Report to be read in conjunction with the Decision Notice.								
Signed:	Officer:	MC	Date:	09/12/2025	Manager:	LH	Date:	12/12/25

Application Ref:	3/2025/0761			 Ribble Valley Borough Council www.ribblevalley.gov.uk
Date Inspected:	06/11/2025	Site Notice:	n/a	
Officer:	MC			
DELEGATED ITEM FILE REPORT:				APPROVAL

Development Description:	Proposed stables, tack room and muck midden. Proposed agricultural storage building and associated hard standing
Site Address/Location:	Eastham House Barn, Clitheroe Road, Mitton, BB7 9PH

Client Mr and Mrs Bowen		
Project Proposed Stables and Storage Building at Eastham House Barn Clitheroe Road Milton Clitheroe BB7 9PH		
Drawing Title Proposed Plans and Elevations		
Scale 1:100/200 @ A2	Date May 2025	Drawn LFR
READ DESIGN LTD		
169 - 02 E

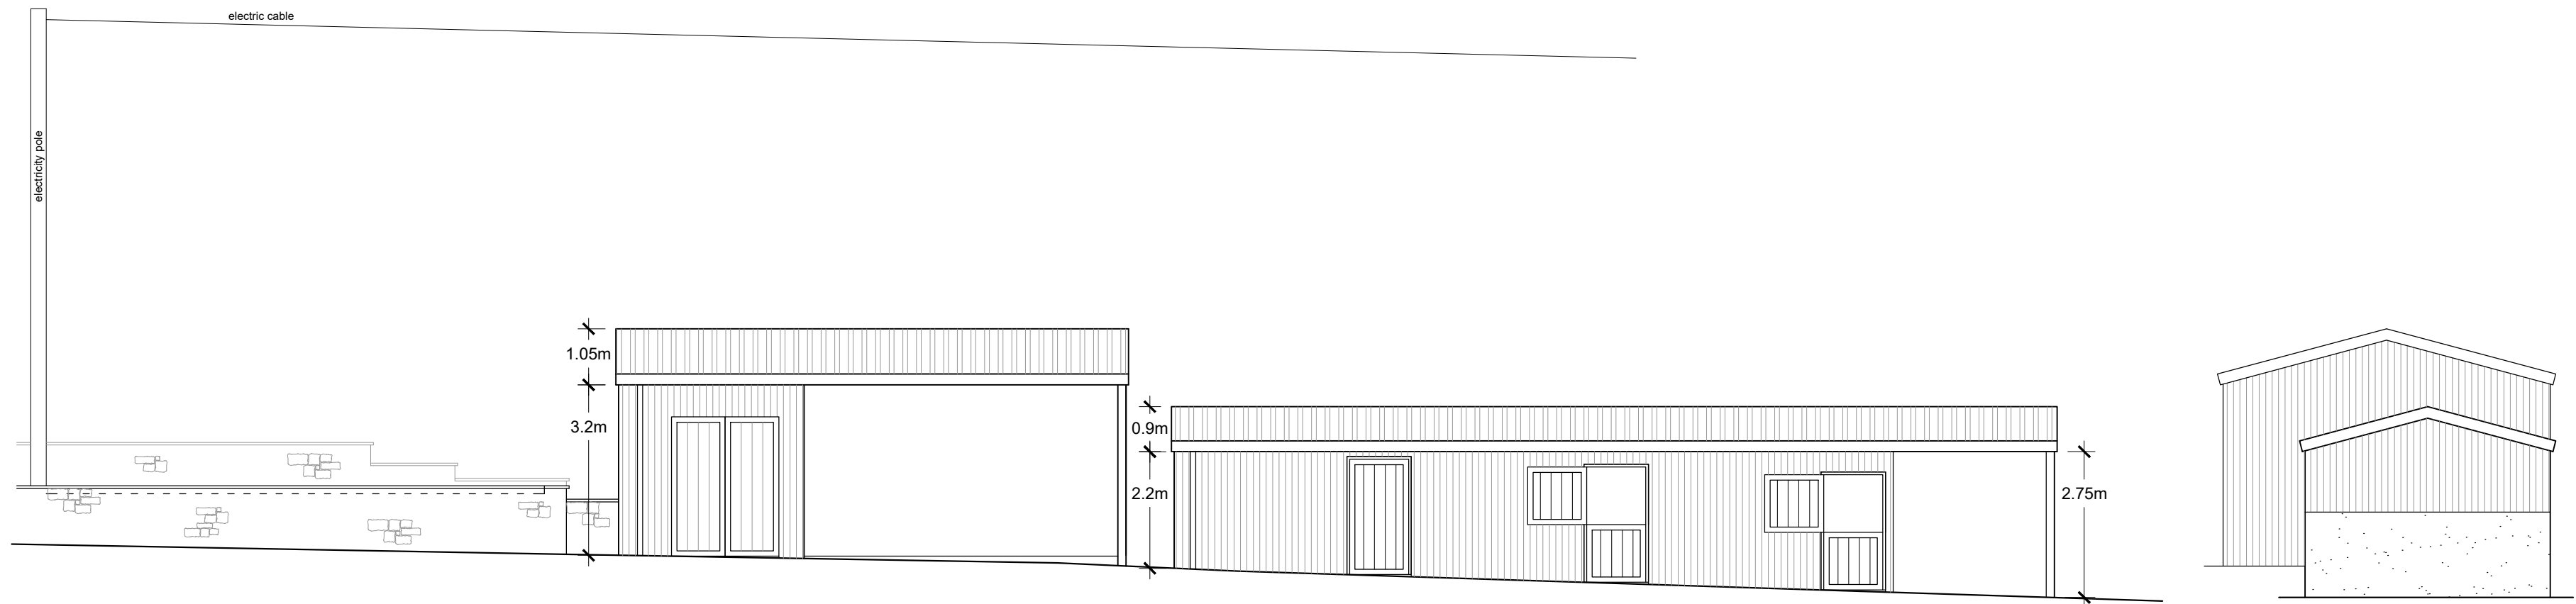
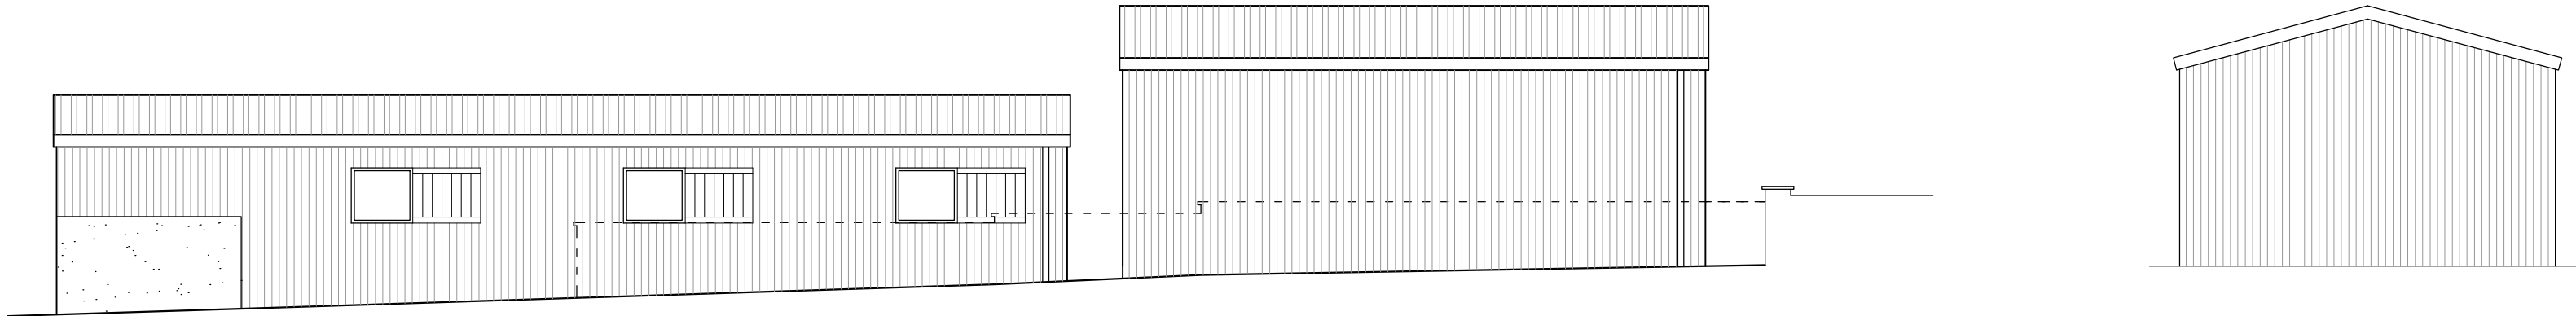
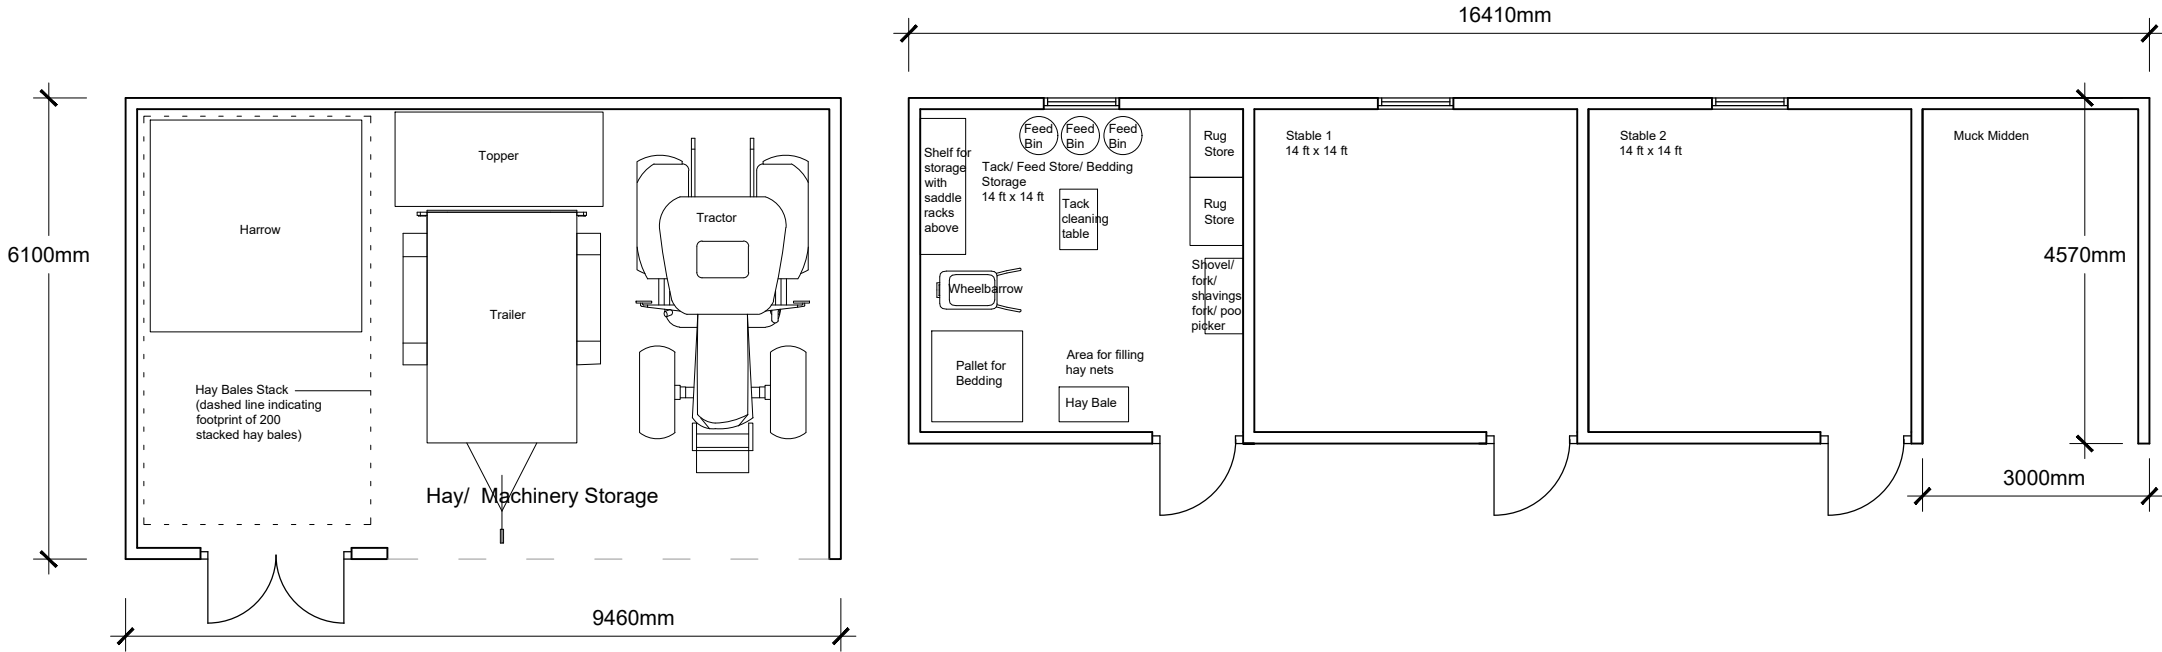
Amended drawings have been received following concerns raised with regards to the size of the building. As such, the building has been split into two and now includes a taller agricultural machinery building which would be approximately 9.46m in length, 6.1m in depth, would have an eaves height of approximately 3.2m and a total height of 4.25m. This building would be part open fronted but would include a section with double doors. The stable building would be sited adjacent to the agricultural machinery store and would have 3 no. stables, a tack/store room and a muck midden. The stables would be approximately 16.4m in length, 4.75m in depth, would have an eaves height of approximately 2.2m and a total height of approximately 3.1m. The amended stables would now have two stable doors, a pedestrian door and the muck midden would be open.

The building has now been split into two buildings, leaving a gap of approximately 0.9m between the two. The amendments have resulted in the stable building extending slightly further into the field to the east. However, the resultant eaves height has now been reduced and the separation between the two buildings is considered to reduce the overall bulk of the built form.

The report also includes species enhancements for bats and birds and includes the installation of 1 no. bird box and 1 no. bat box on the north-east and south-east elevations of the building. Updated elevation plans are required to respond to the amended building design/heights however it is considered that this could be secured by way of planning condition.

Proposed Site Plan 1:200

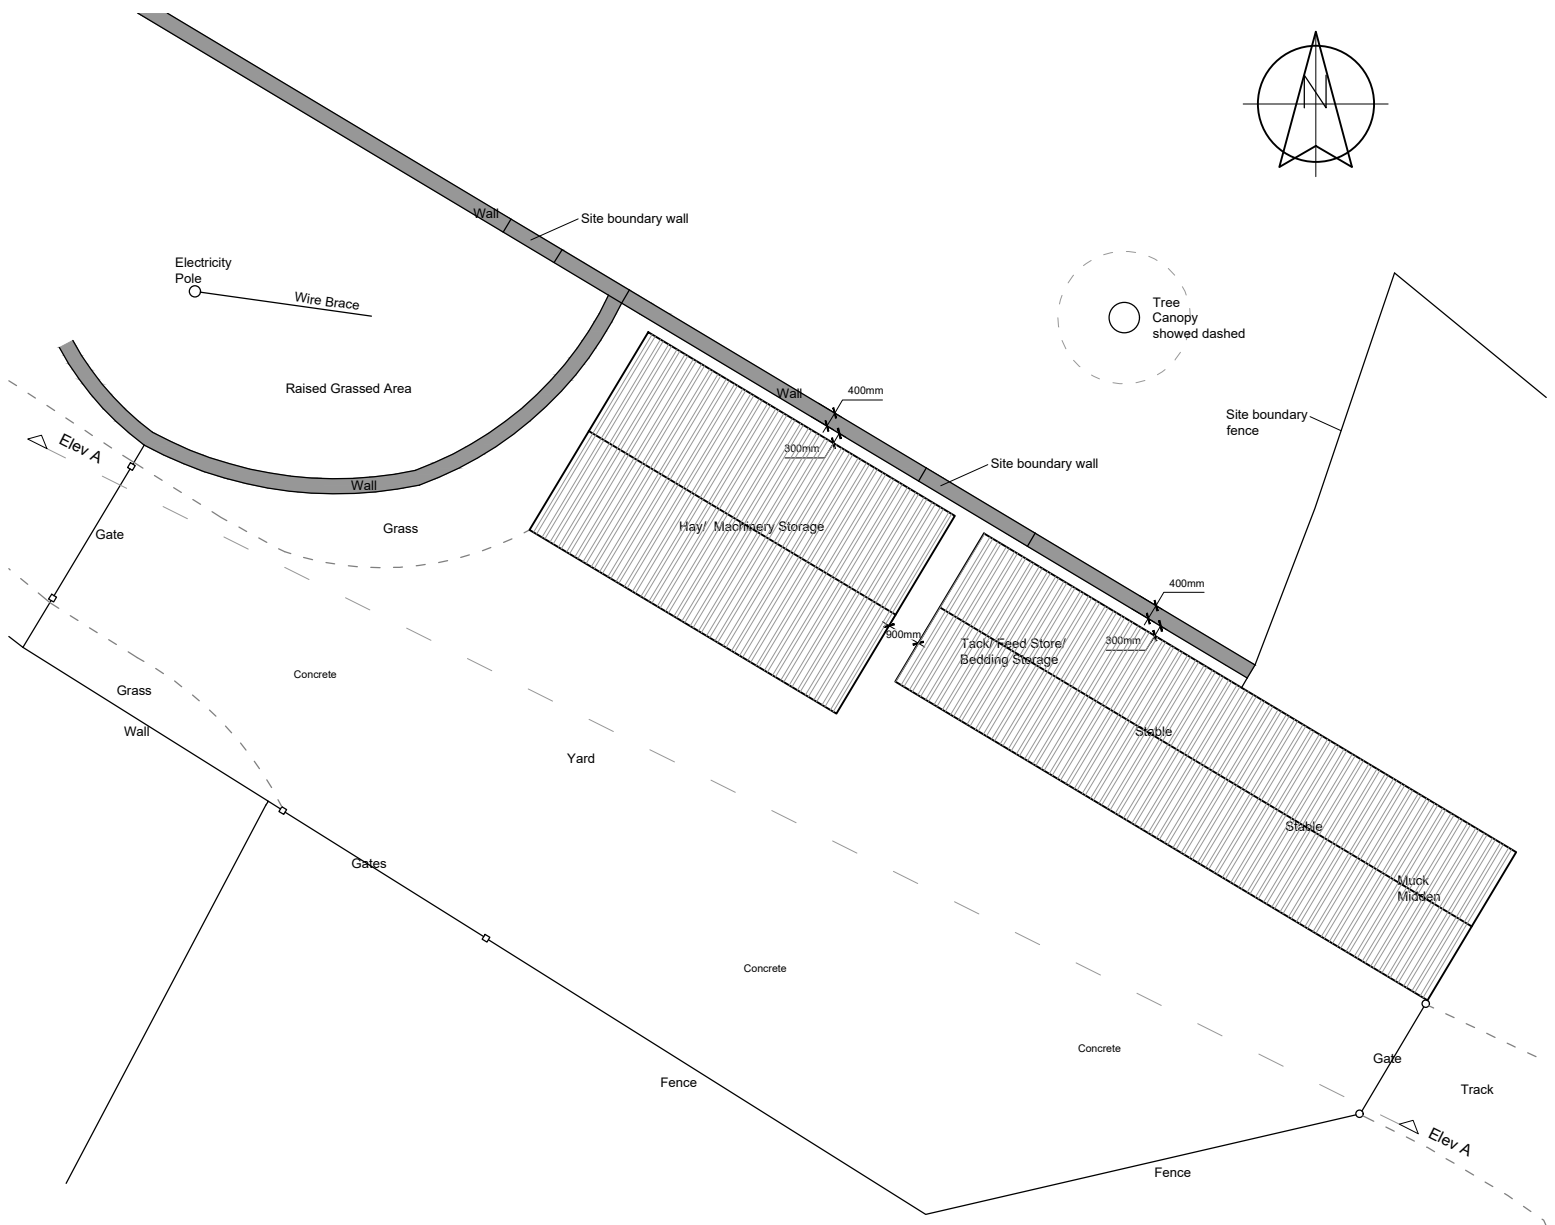
It should be noted that there is an existing tree located to the north of the proposed building, outside the ownership of the applicant. An updated site plan has been provided which demonstrates the tree canopy is located 5 metres away from the proposed buildings and as such, the proposal is not likely to result in harm to the adjacent tree.

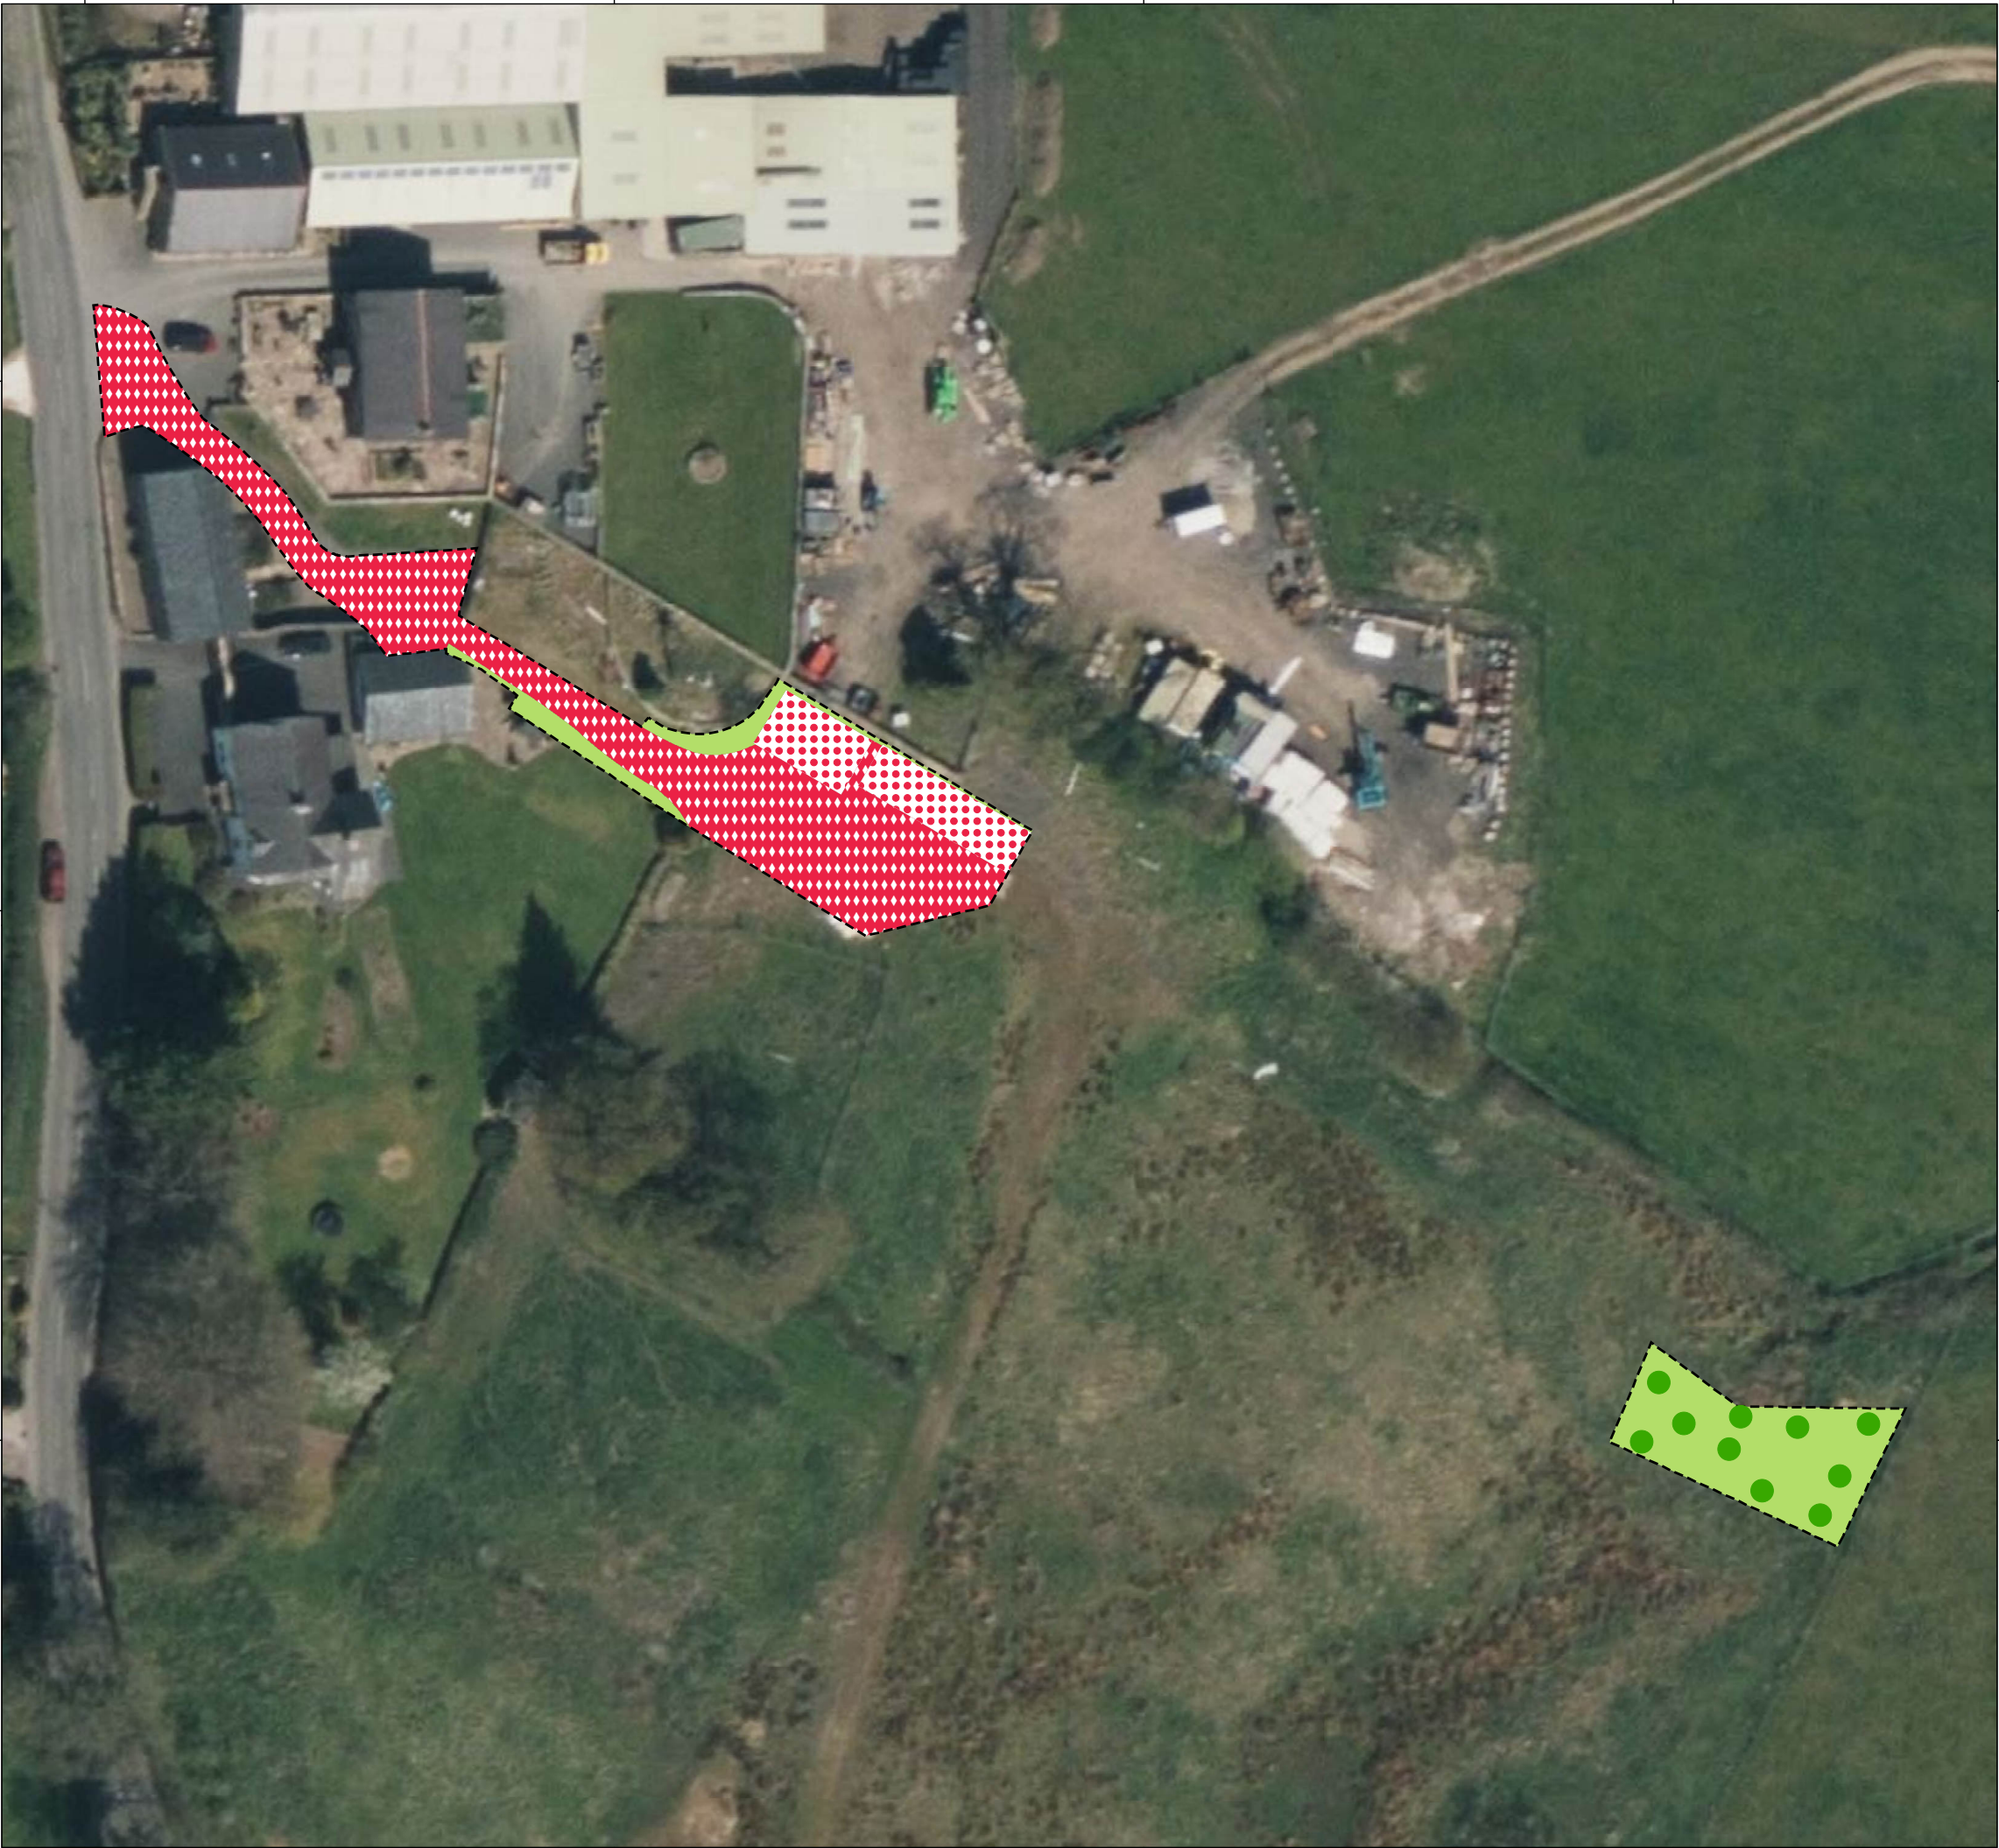
With regards to Biodiversity Net-Gain, the amended submitted Biodiversity Metric indicates that the proposals would result in a net-gain of biodiversity value for habitats units of 12.33% which would be achieved through the planting of 10 native trees within a field approximately 76 metres to the south-east of the proposed building. The report also concludes that the created habitats do not represent significant net gain and the habitat creation is not considered significant enough to warrant the provision of a 30-year Habitat Management and Monitoring Plan. However, a Biodiversity Retention and Enhancement Plan (or similar) is recommended with respect to the tree planting. It is considered that an appropriately worded condition could be added to any grant of permission to ensure the retention and management/monitoring of the new habitat that is proportionate to the development.
